RE: REVISED DRAINAGE PLAN FOR AN ADDITION TO AUTO-CHLOR SYSTEM OF
ALBUQUERQUE (H16-D114) REVISION DATED 3/6/96.

RE: DRAINAGE PLAN FOR AN ADDITION TO AUTO-CHLOR SYSTEM
OF ALBUQUERQUE (H16-D114) ENGINEER'S STAMP DATED 2/20/96.

PROJECT TITLE: ADDITION TO AUTO-CHLOR
SYSTEM OF ALBUQUERQUE ZONE ATLAS/DRNG. FILE #: H16/D114

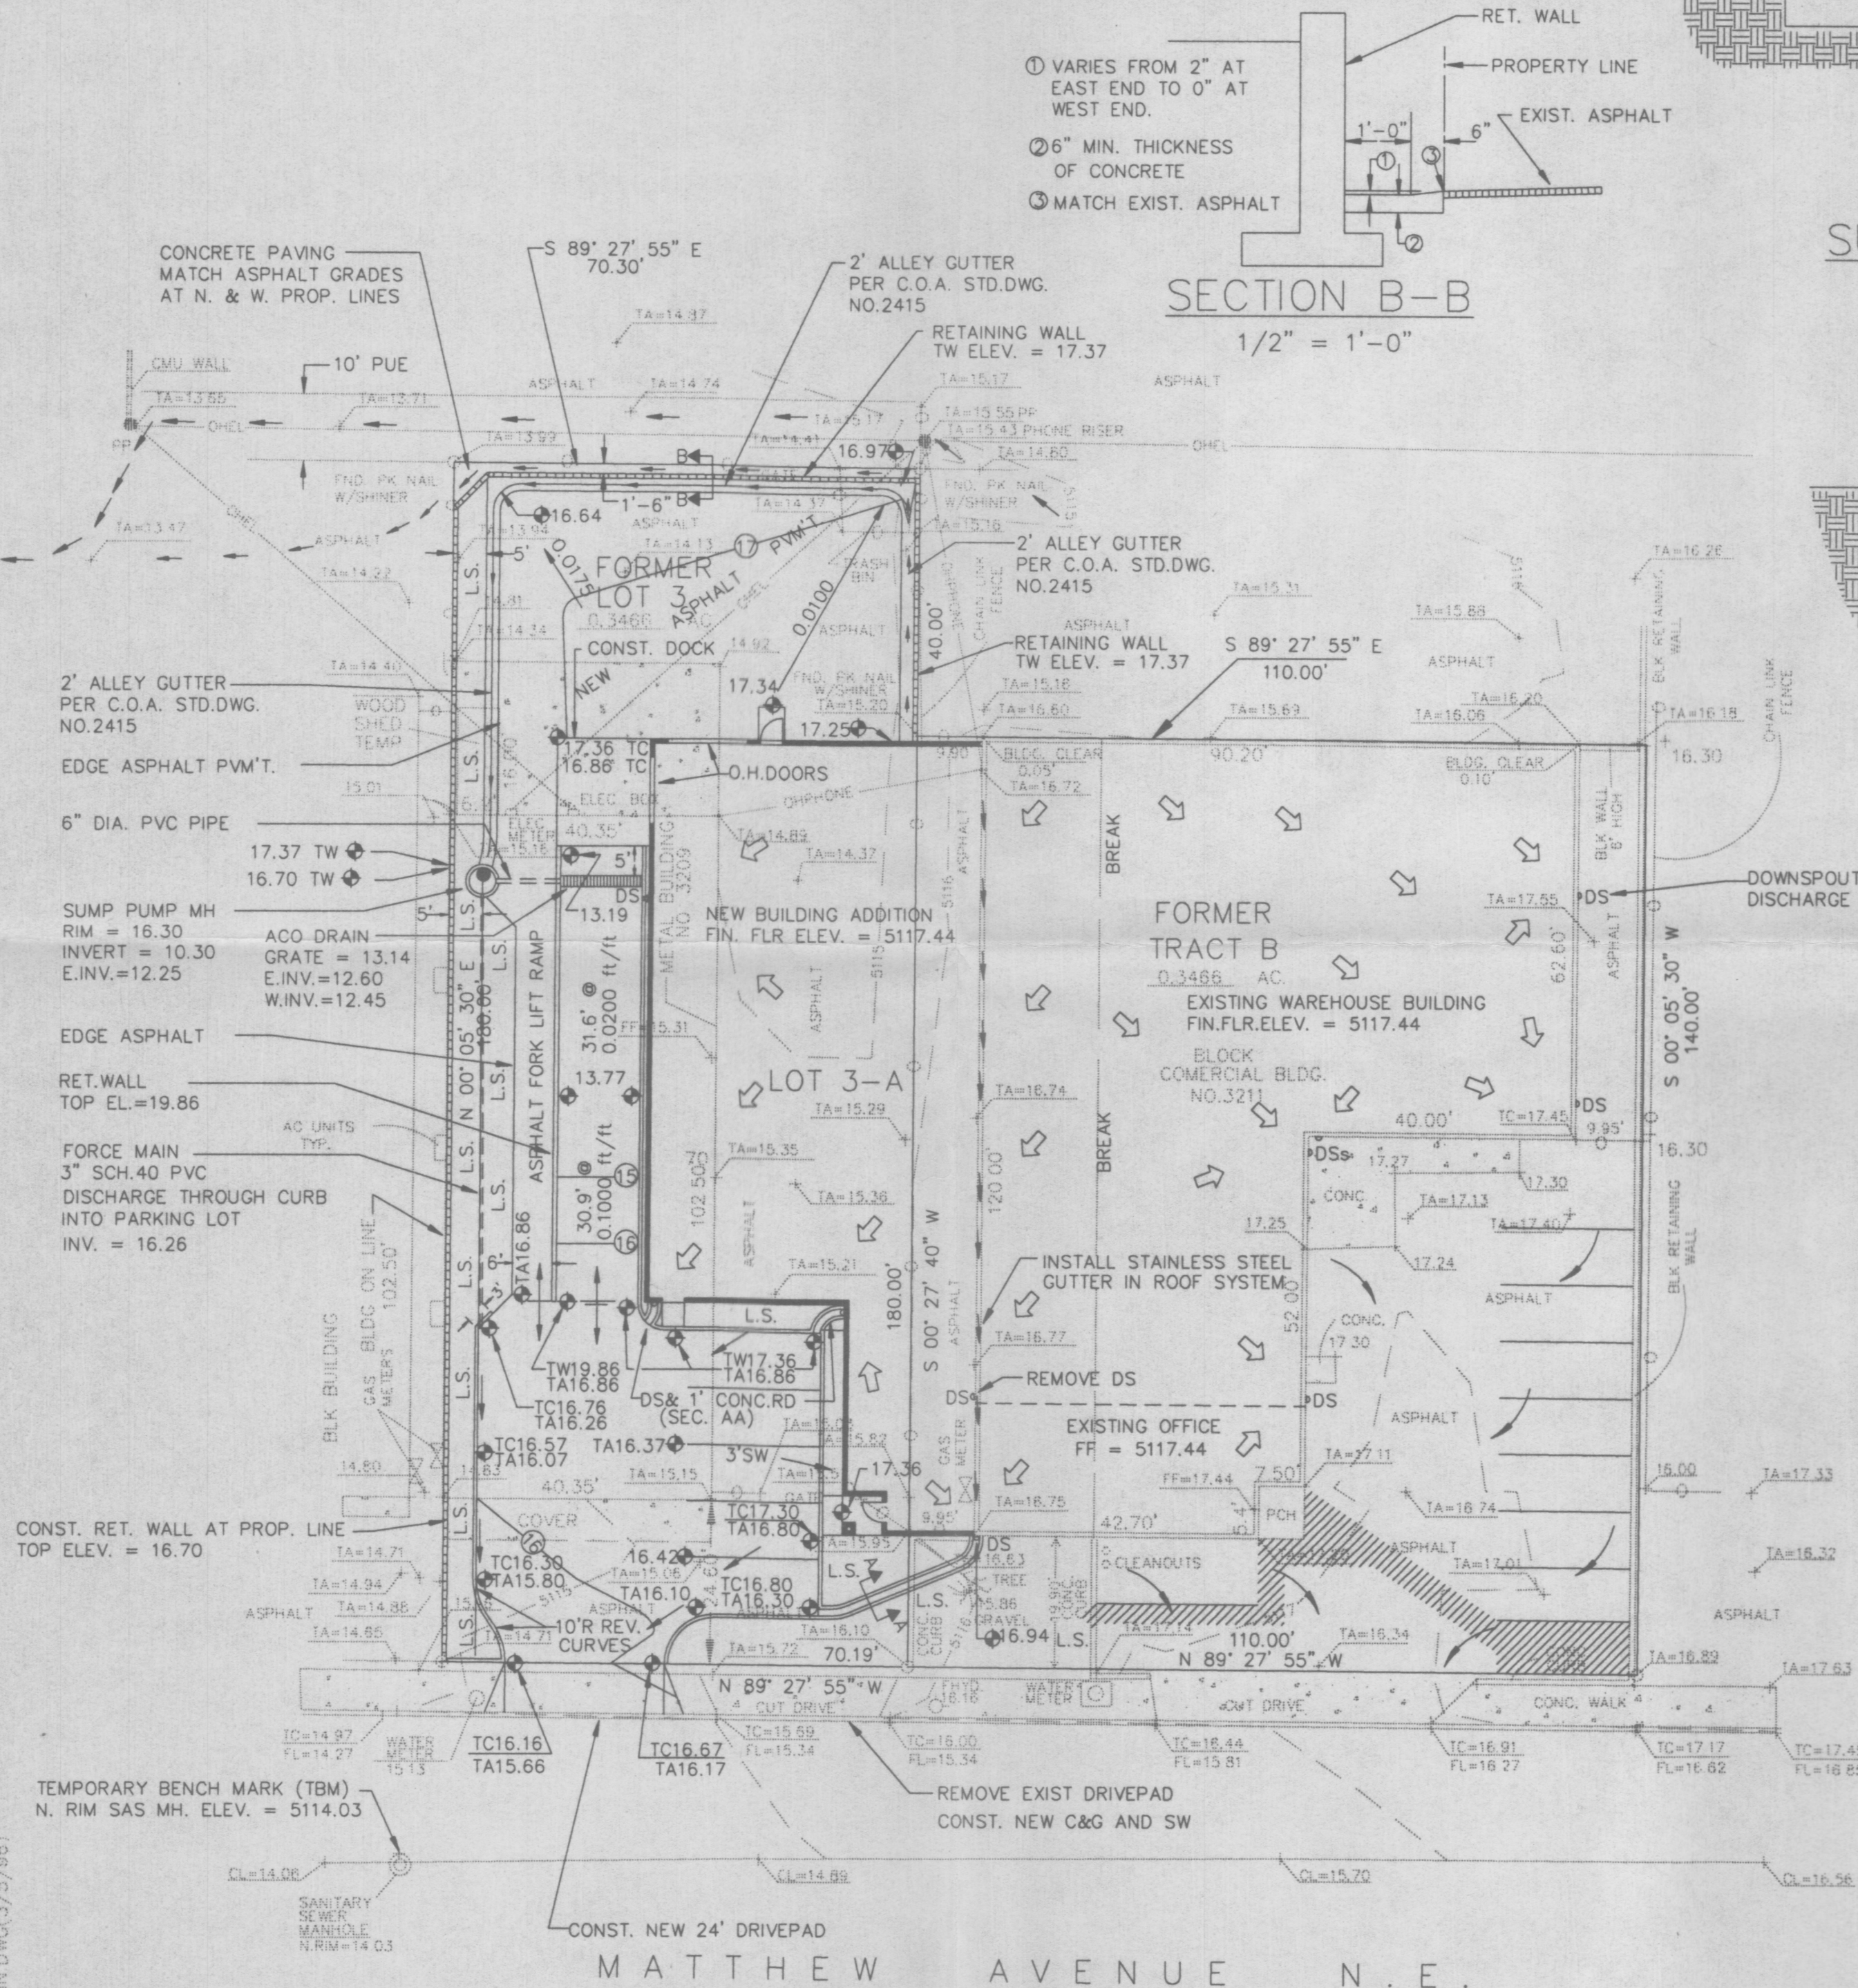
1. ✓ I am unable to determine why you need Std. DWG. 2235 from your plan drawing.
2. ✓ Grades on the northeast corner of the site seem to indicate that you may be blocking off-site flows with your proposed retaining wall.
3. ✓ If this site deals with chemicals, you must coordinate with Loren Meinz, EPA representative for the City.
